Consultation Response from KC, Highways Development Management		
2021/91208 Former Pizza Hut Restaurant, Centre 27 Business Park, Bankwood Way, Birstall, Batley, WF17 9TB		
Installation of drive-thru lane and associated engineering works, alterations to car parking and servicing arrangements and associated changes to landscaping. Demolition of existing enclosed yard and provision of replacement bin store, minor alterations to the building and elevations including recladding		
Date Responded: 02/06/2021	Responding Officer: Zack Turner	Responding Ref: K13-9/1

2021/91208

This application is at Former Pizza Hut Restaurant, Centre 27 Business Park, Bankwood Way, Birstall, Batley. The proposal is for the installation of a drive-thru lane and associated engineering works, alterations to car parking and servicing arrangements and associated changes to landscaping. Demolition of existing enclosed yard and provision of replacement bin store, minor alterations to the building and elevations including recladding.

P
PLAN
PROPOSED GA PLAN
SCALE 1:100 @ A1

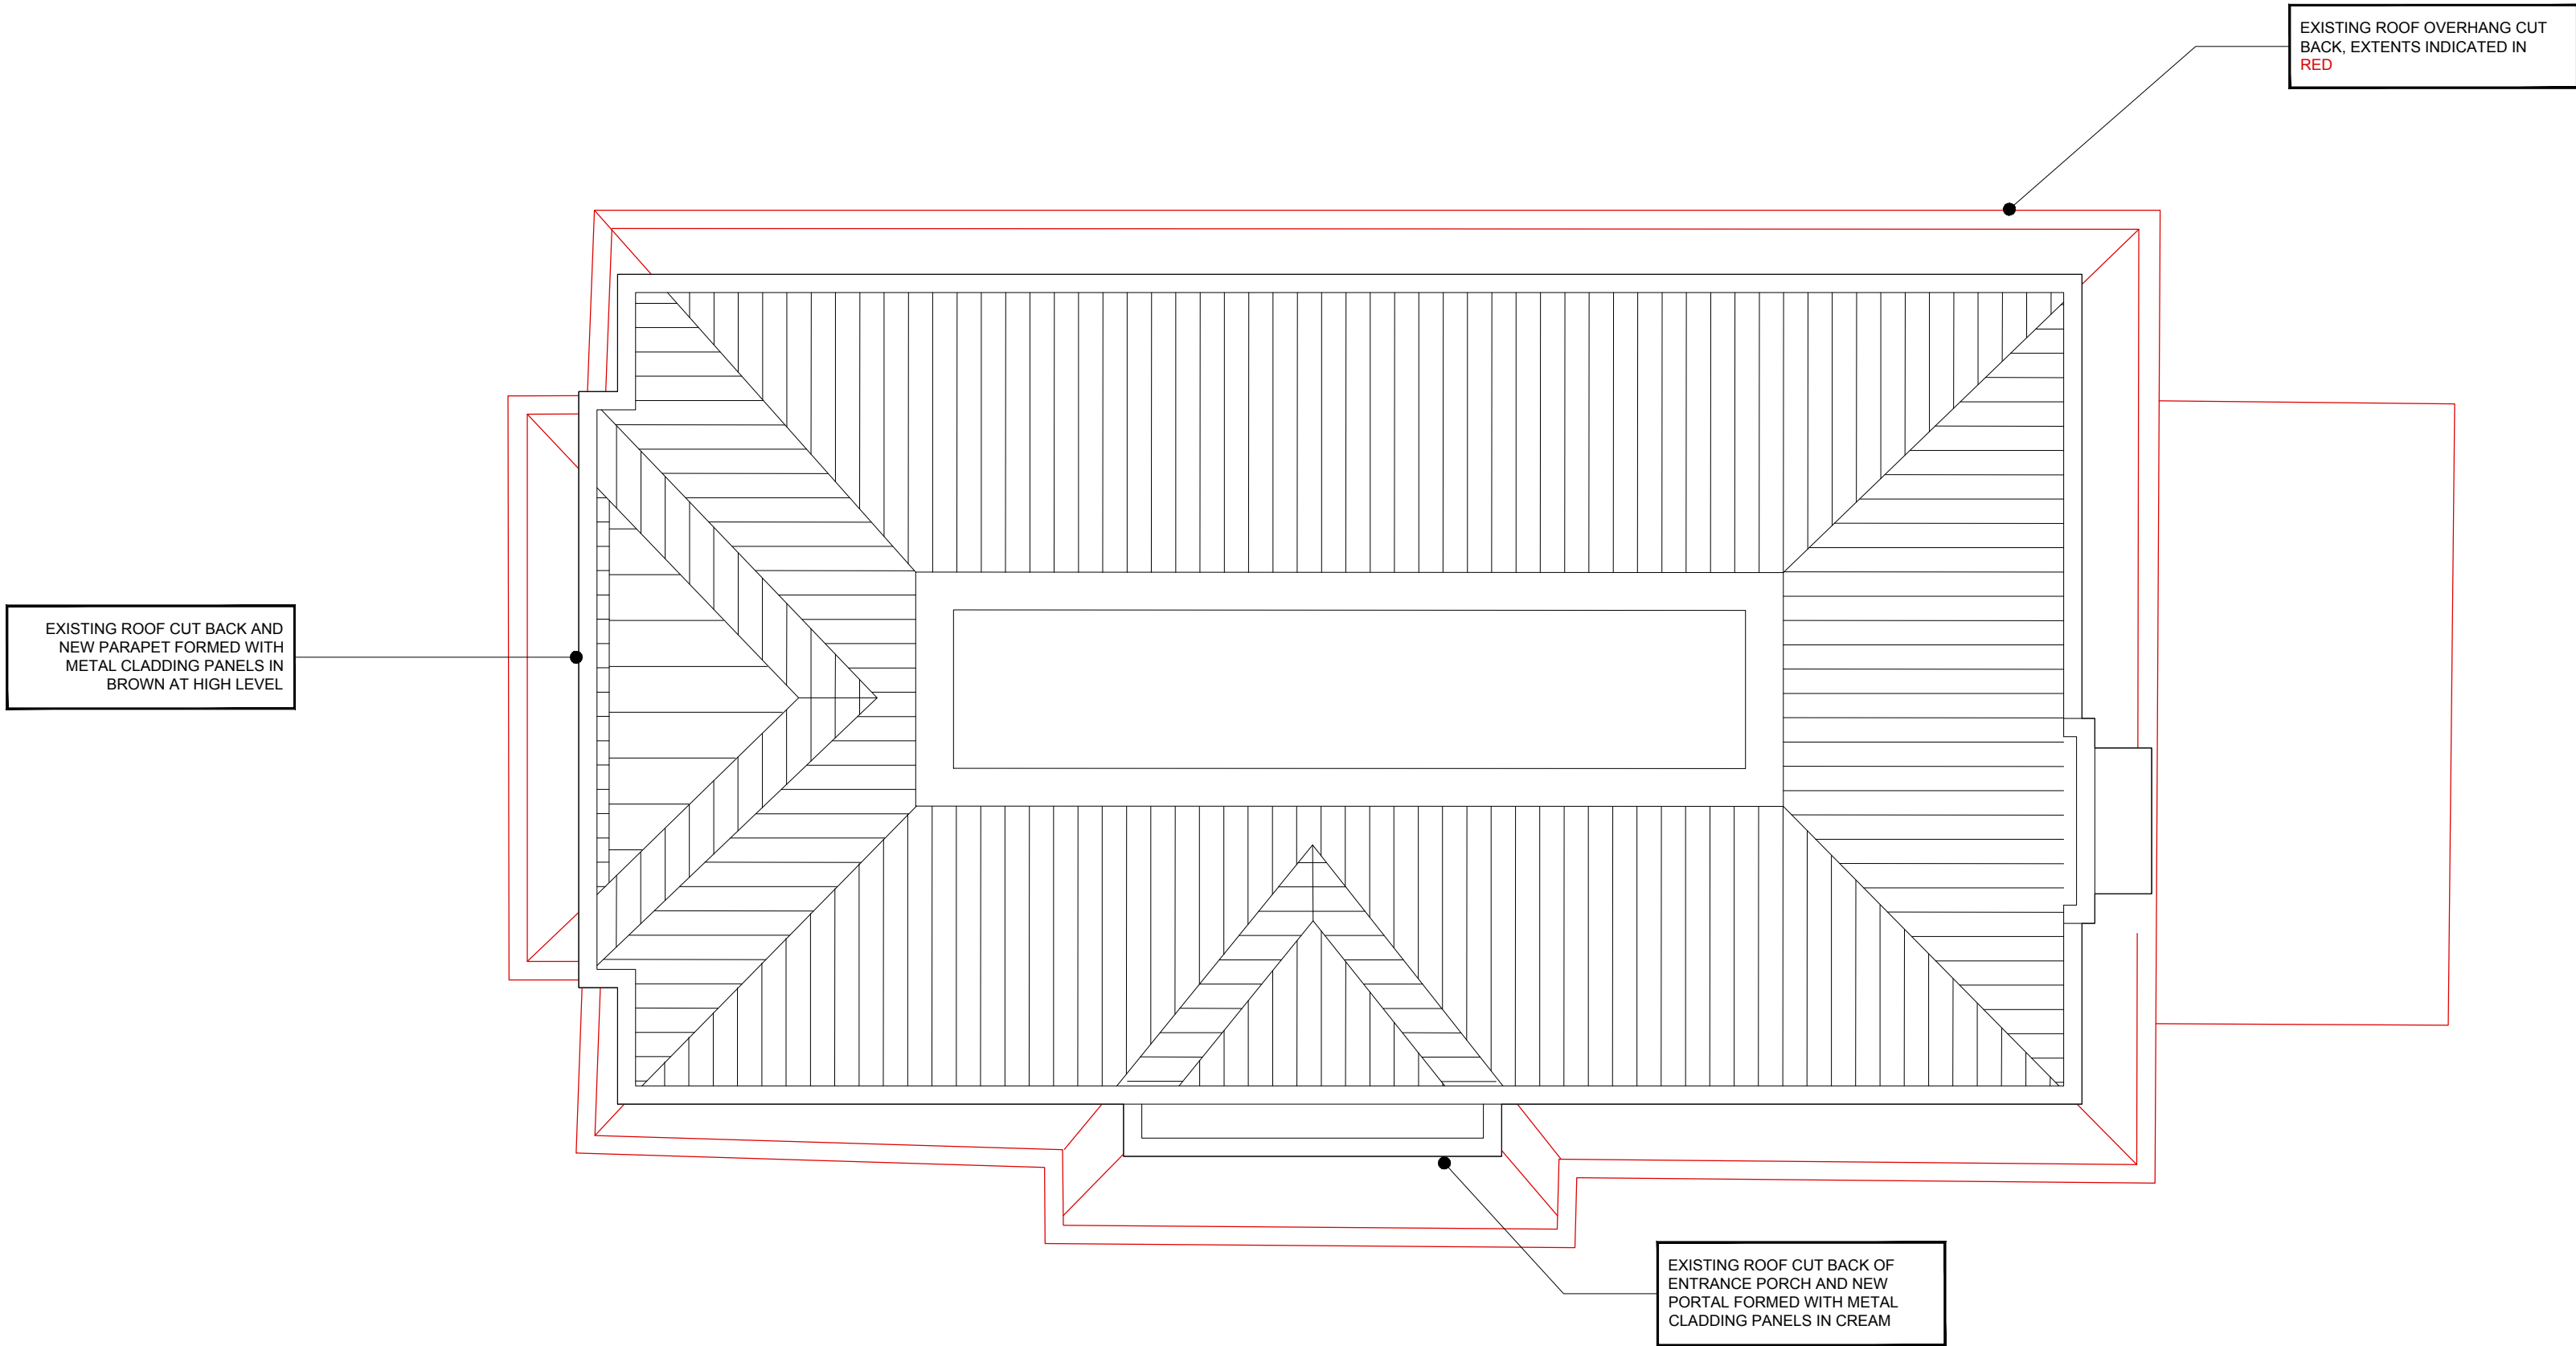
Each parking space including the area around the disabled parking spaces has been presented with the correct dimensions.

The drive through lanes are a minimum of 3.1m wide which is of sufficient width.

There will be 4 cycle racks adjacent the store entrance to accommodate 8 cycles.

A suitable area has been demonstrated for deliveries at the site.

Bin storage has been presented in a suitable location between the building and parking bays, and waste collection is where deliveries will take place.

The parking space adjacent the bin store appears to be tight on accessibility. It may become apparent that this space is unusable so it should be considered to extend the hatching for the bin store across this parking space.

Prior to the development being brought into use, the proposed car park hereby approved shall be marked out into bays in accordance with details that have previously been approved in writing by the Local Planning Authority.
